## REQUEST

Current Zoning: R-3 (single family residential)  
Proposed Zoning: O-1(CD) (office, conditional)

Approximately 7.07 acres located at the intersection of Zoar Road and Thomas Road, south of Youngblood Road.

The petition proposes to reuse the existing structures on the site to allow for office, research, educational, and dormitory uses for the F.A. Bartlett Tree Expert Company.

RZ1.0

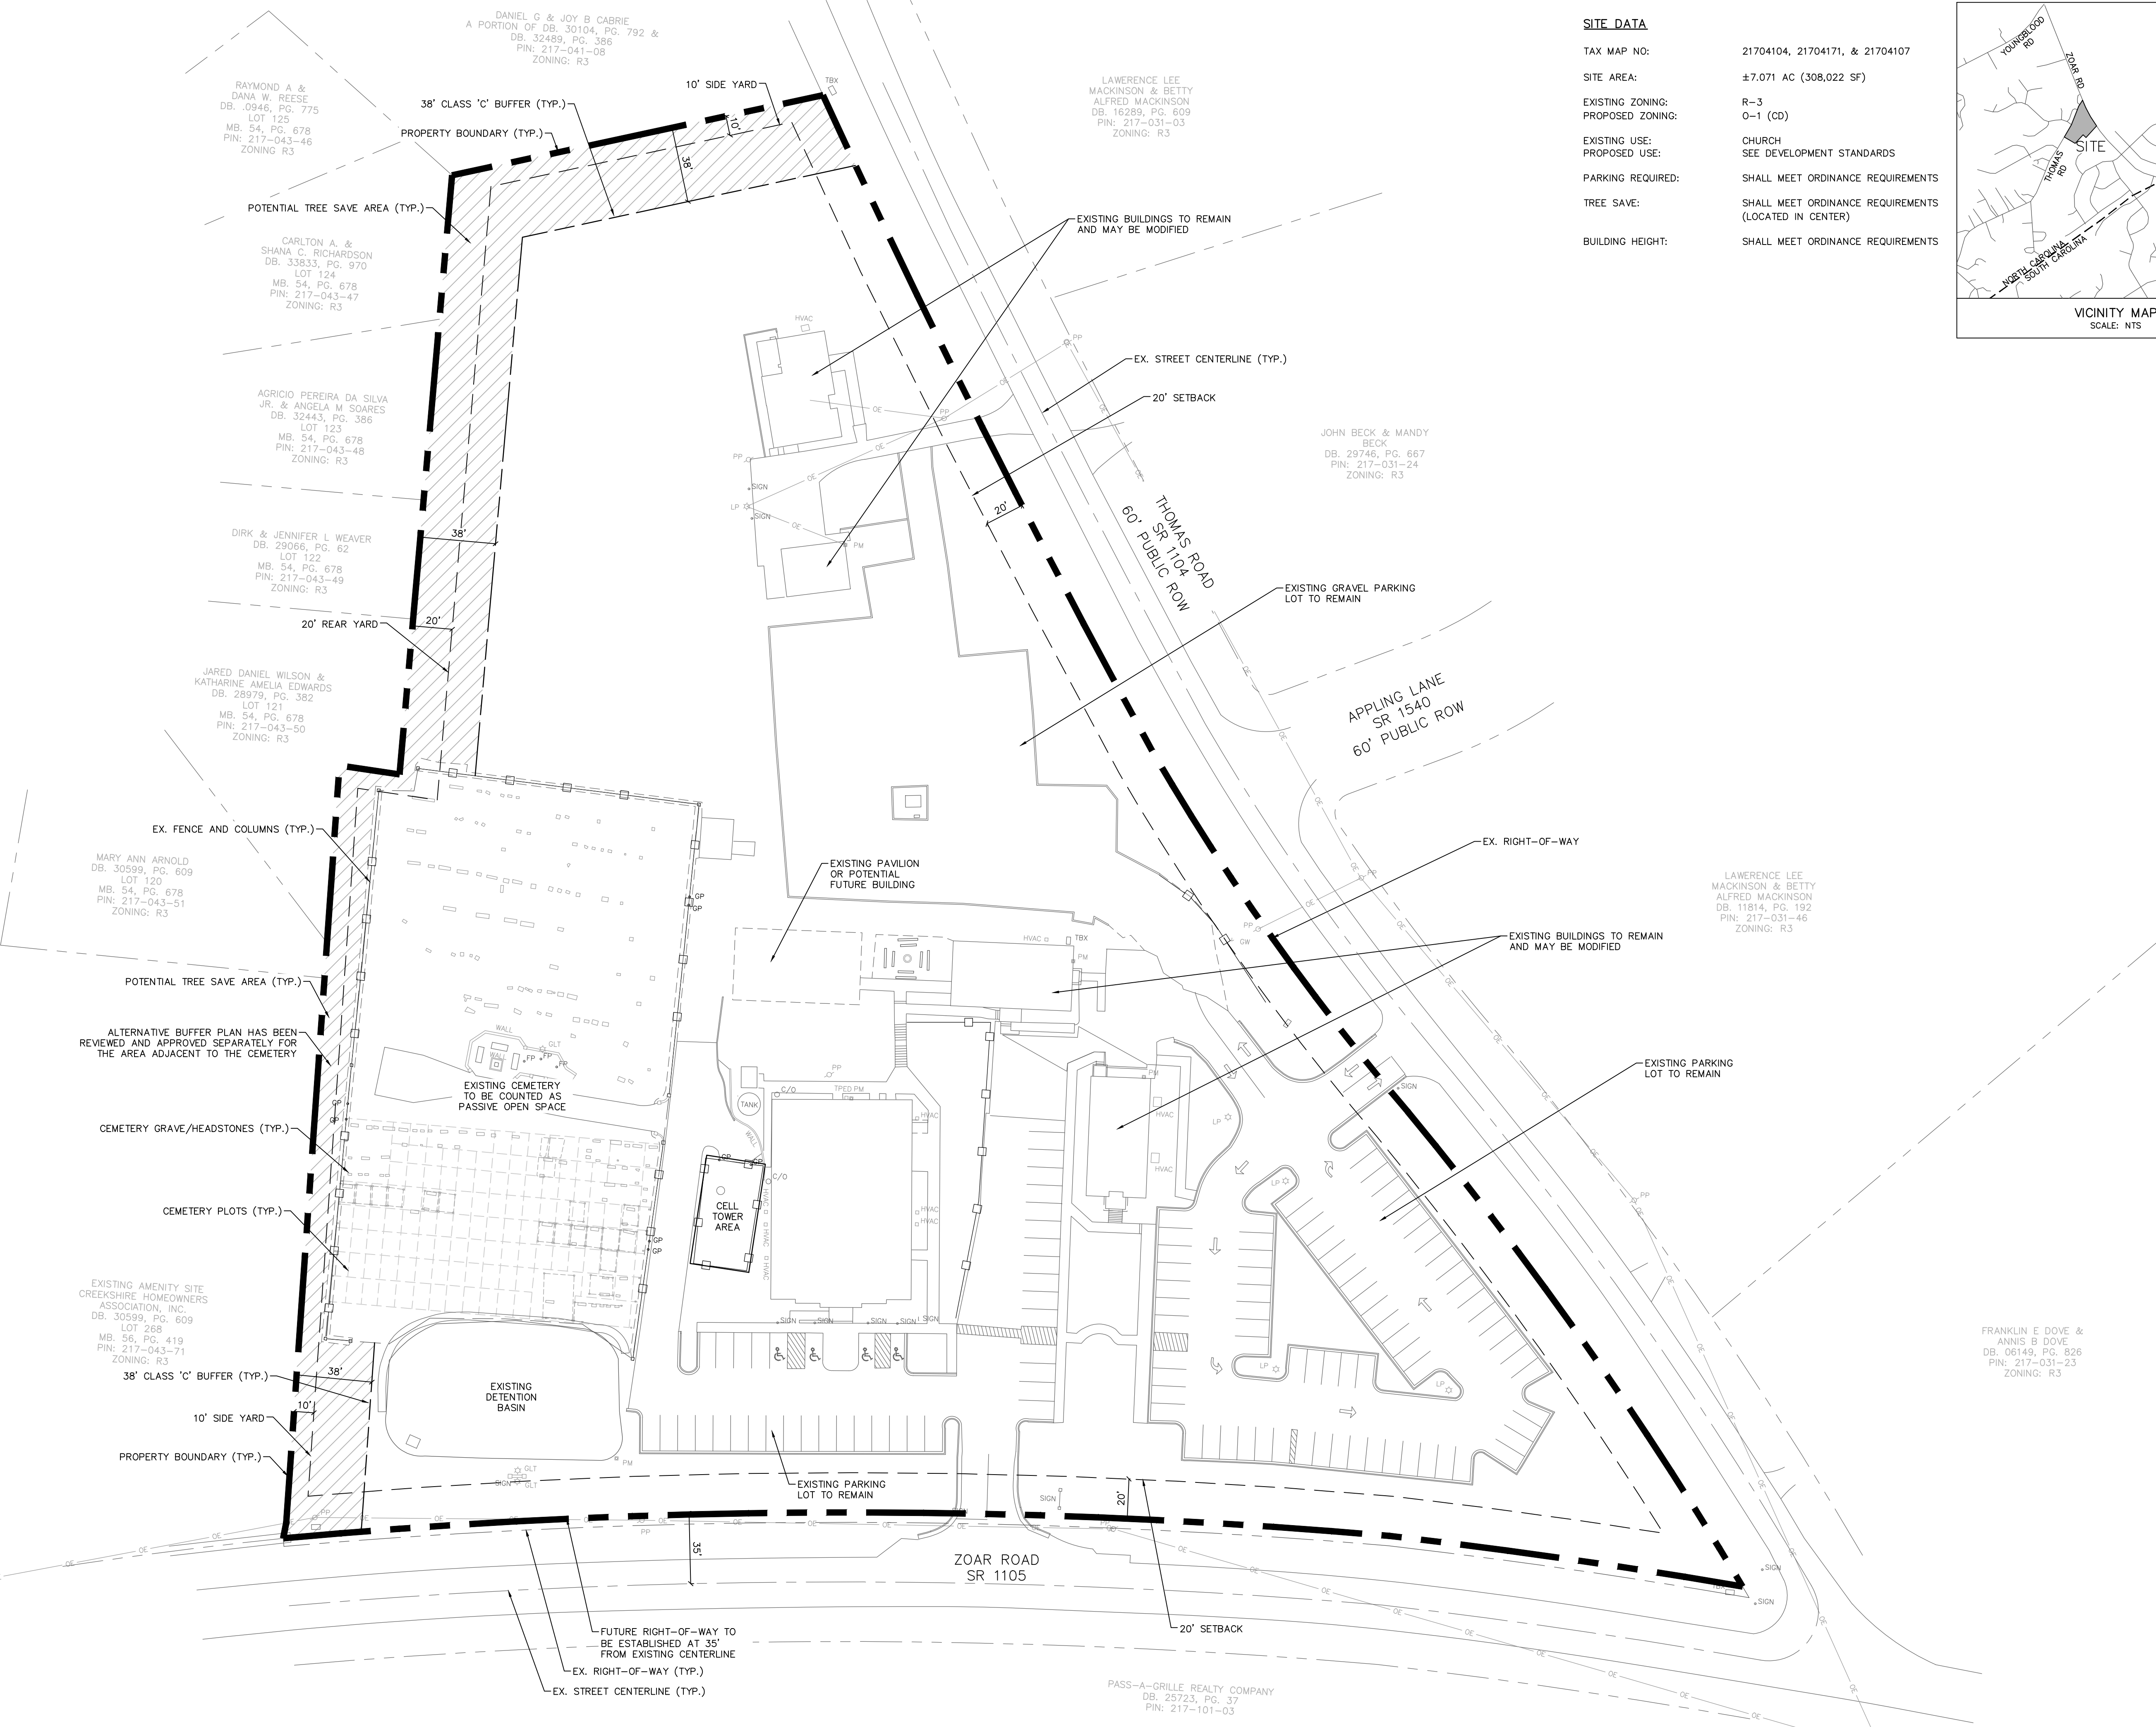
1. ~~Dimension the future back of curb from the centerline on both Zoar Road and Thomas Road.~~  
**Addressed**
2. ~~Revise conditional notes to commit to dedicate 35.5 feet of right of way from the road centerline on Zoar Road.~~ **Addressed**

3. ~~Revise the site plan and notes to commit to extend the sidewalk on Zoar Road across the site's frontage.~~ **Addressed**
4. ~~Add conditional note specifying "the Petitioner shall dedicate and convey in fee simple all rights of way to the City before the site's first building certificate of occupancy is issued. CDOT requests rights of way set at 2' behind back of sidewalk where feasible."~~ **Addressed**

6. ~~If the site is to remain in the ETJ: Revise site plan and conditional note(s) to construct 8 foot planting strips and 12 foot sidewalks on Zoar Road and 8 foot planting strips and 6 foot sidewalks on Thomas Road.~~ **Addressed**
